Re: Local Planning Authority Reference EG/69/17/PL

**For: 4 No. live/work units, Research & Development propagation building & growing area, garden room, fuel store & greenhouse to main dwelling & formation of new access.
(Departure from Development Plan)**

At: Swallowfield, Eastergate Lane, Eastergate, PO20 3SJ

Drawing Live/Works Dwellings
Block A Units 1 & 2
Plan, Elevations & Section

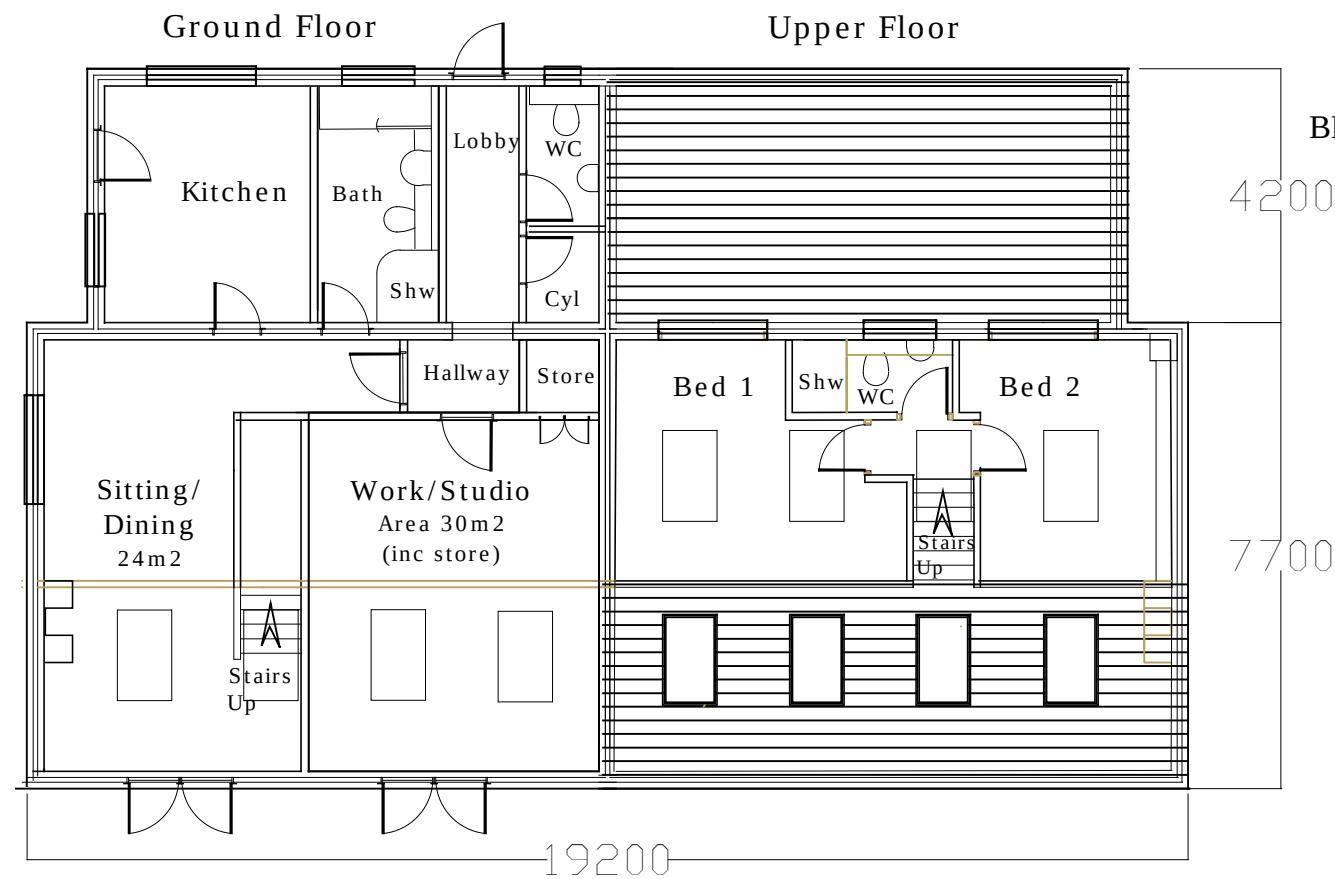
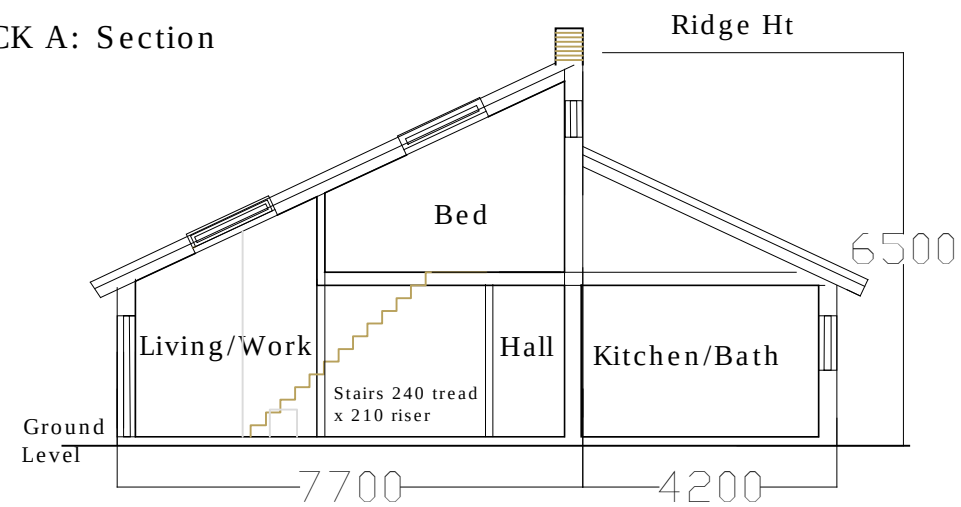
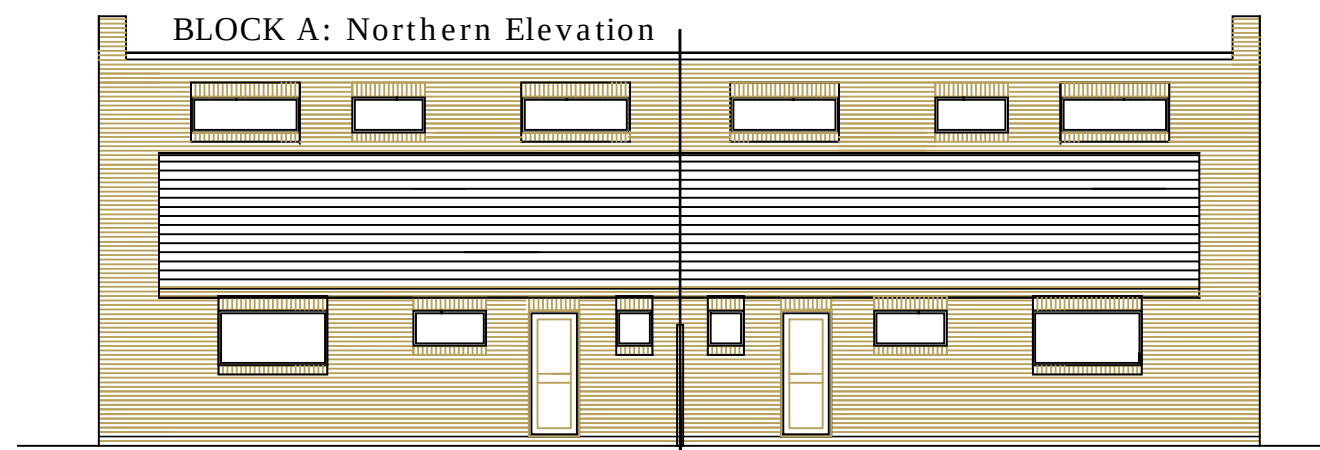
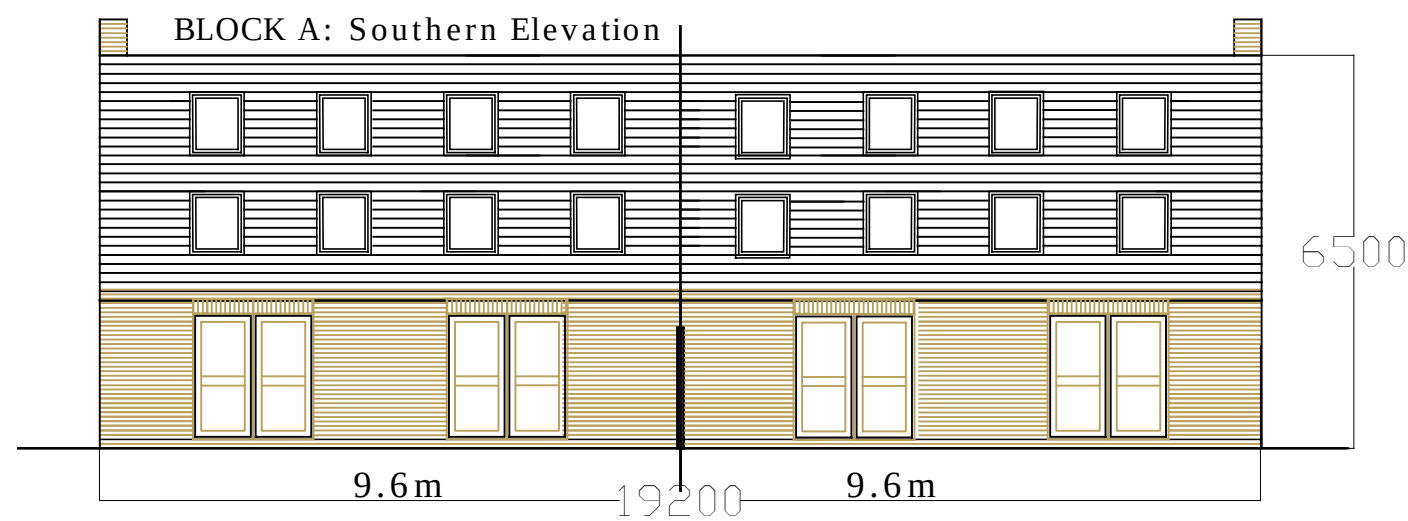
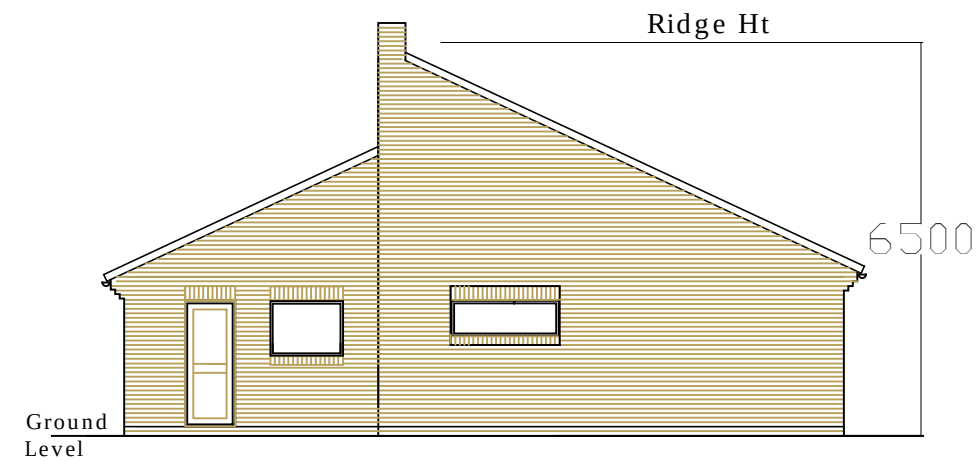
2. **Community Character & Quality of Design:** The proposed development form and built style is ugly and completed out of out of character with the existing urban grain and built form of the area. The work units proposed will sit within a residential area close to private residential properties that are all large and sit within substantial plots, whilst the proposed units are small and will sit within diminutive land parcels.

5. **Visual Privacy:** It is one thing for your private, domestic garden to be overlooked from first floor windows of other private residential properties. This is to be expected and provides only occasional views from non-living room areas that are not subject to intensive day time use. Even in the evenings, such windows would typically be screened by drawn curtains to protect the occupant's own privacy. In commercial premises, such first floor accommodation is typically office space and this is subject to intensive use throughout the day and often late into the evenings through into the weekends, dependent upon the nature of the business. This is obviously going to have a tremendously detrimental and adverse impact upon the privacy of our home reducing substantially not only real levels of existing privacy but also substantially increasing the feeling of being overlooked and supervised on an intensive basis.

Drawing: Proposed Site Development  
Layout  
For: Swallowfield Nursery  
CHICHESTER PO20 3SJ

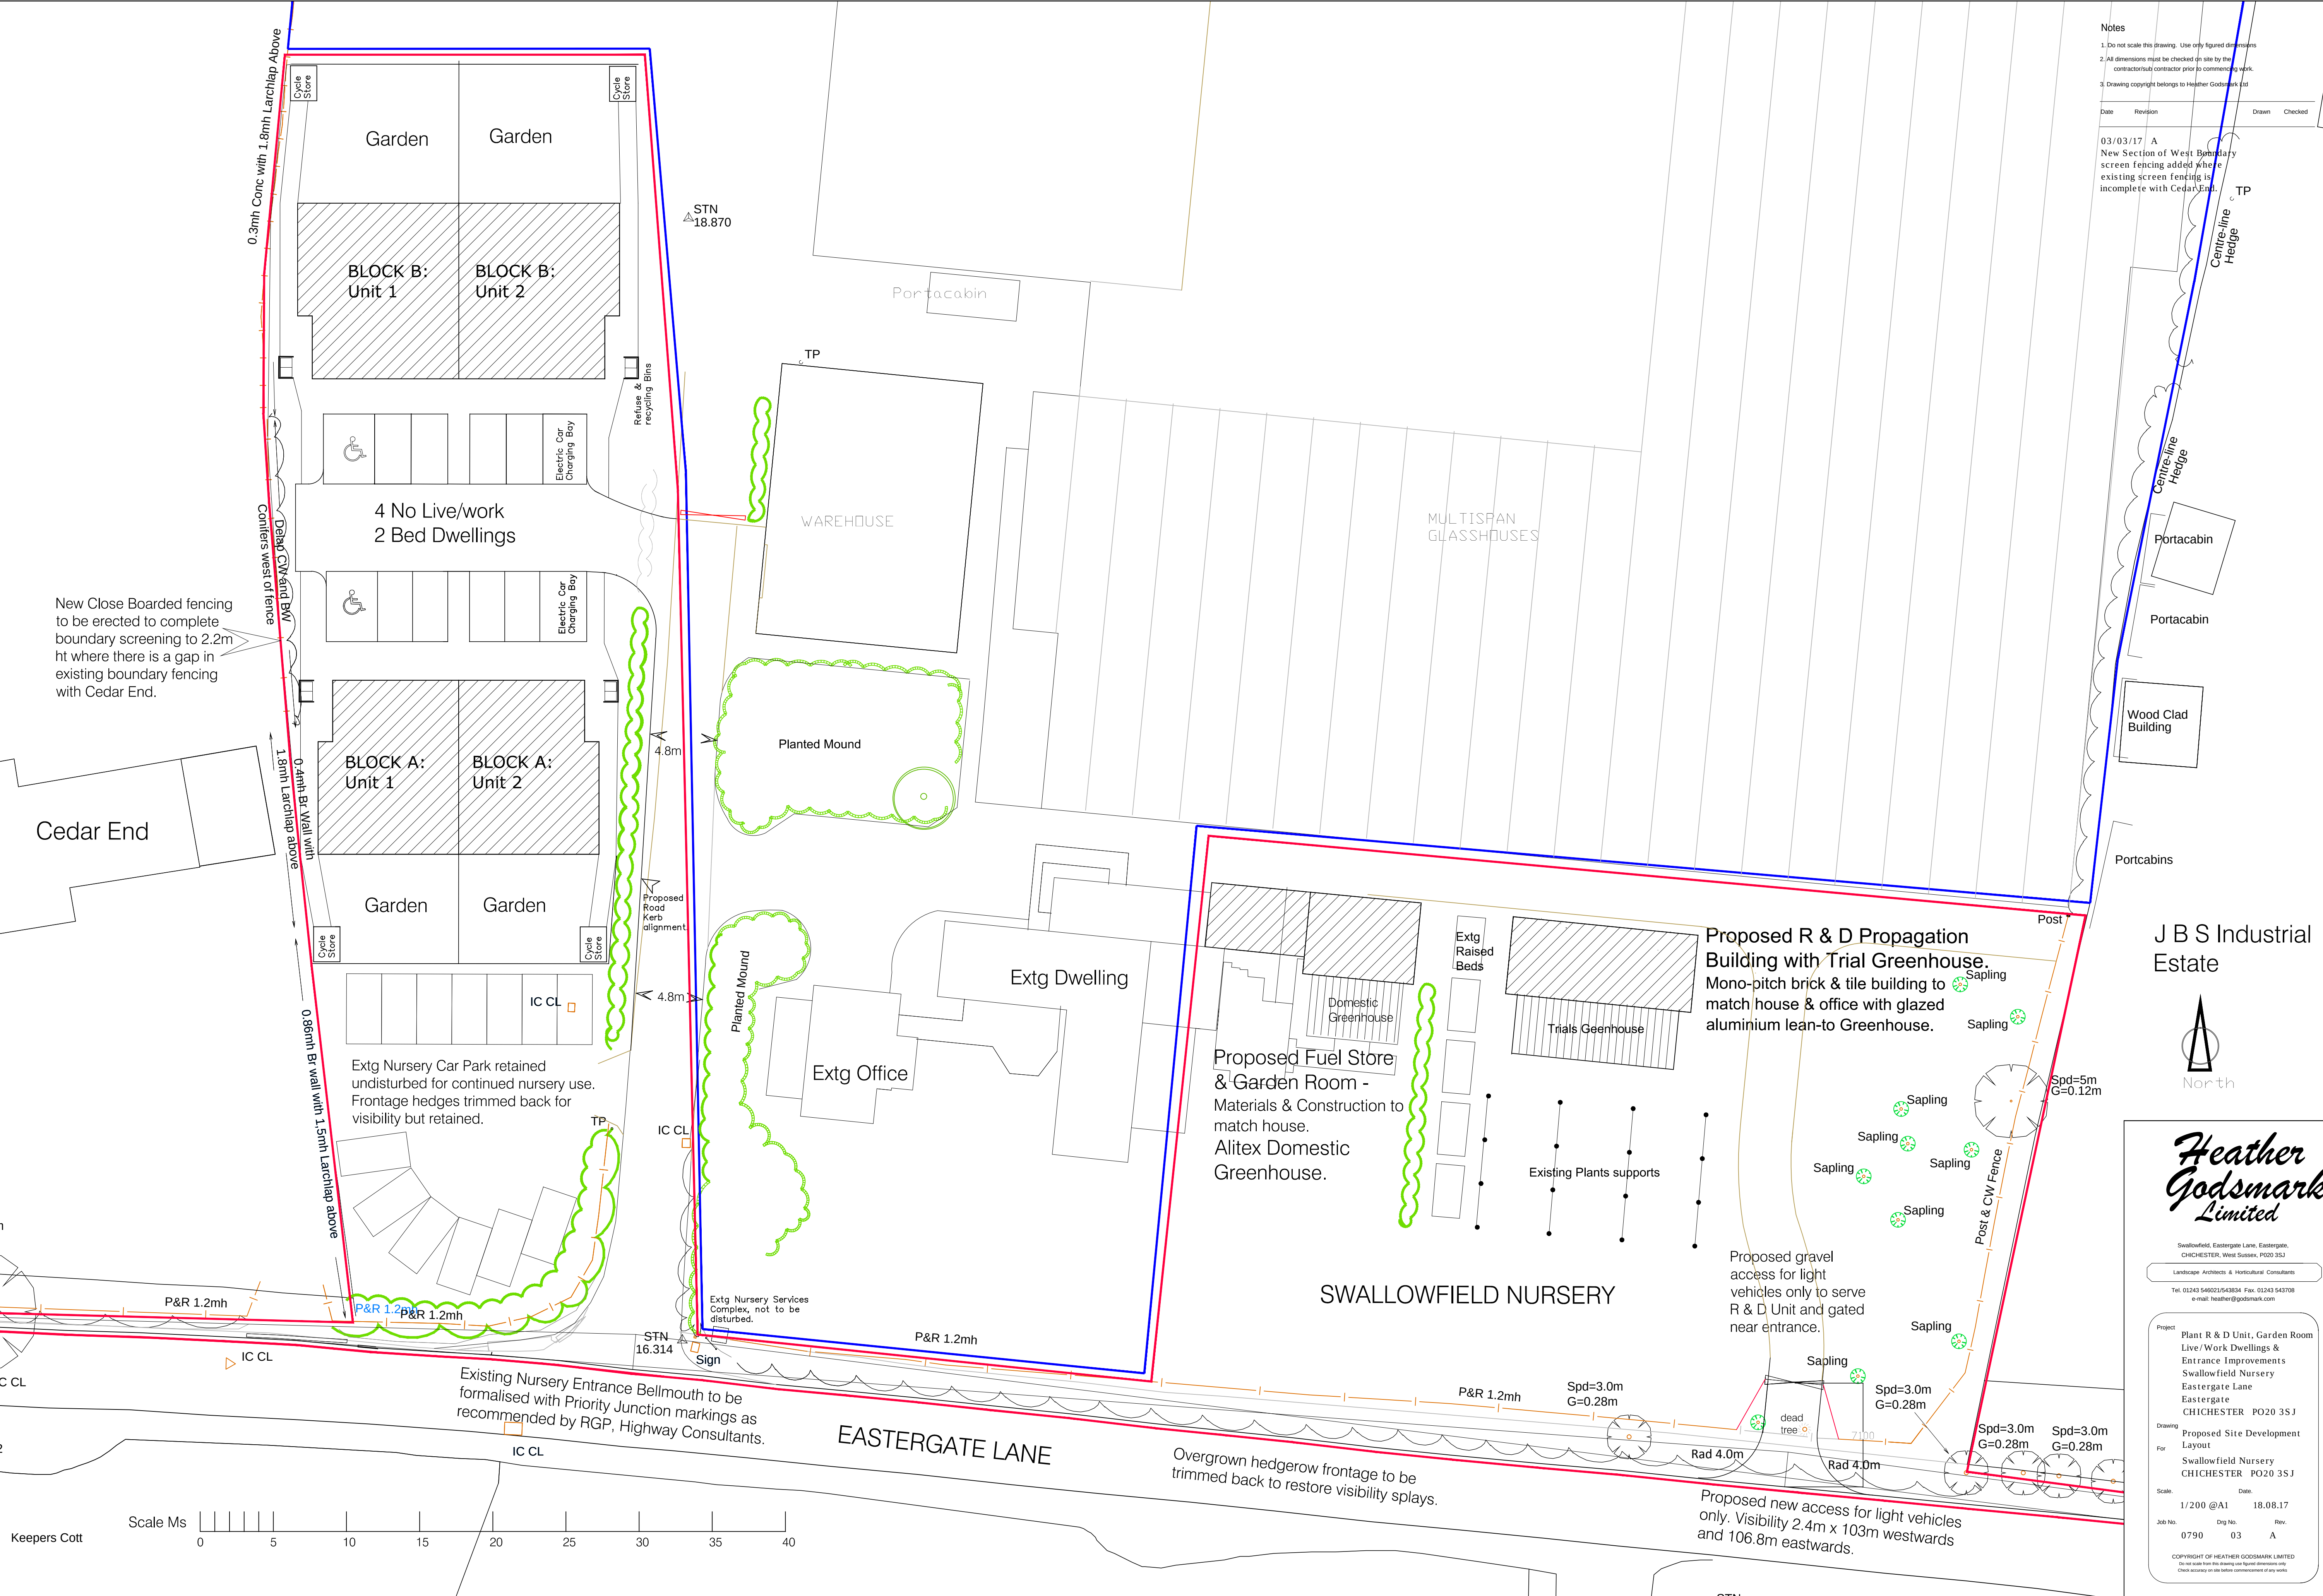
3. **Proximity:** At their nearest the proposed units will sit within just one metre of my private garden boundary. This is not even enough distance to have meaningful boundary landscaping, provide clear access between the new building and such planting and maintain a reasonable separation to ensure commercial activity is not within an intrusively close distance to the private garden boundary.
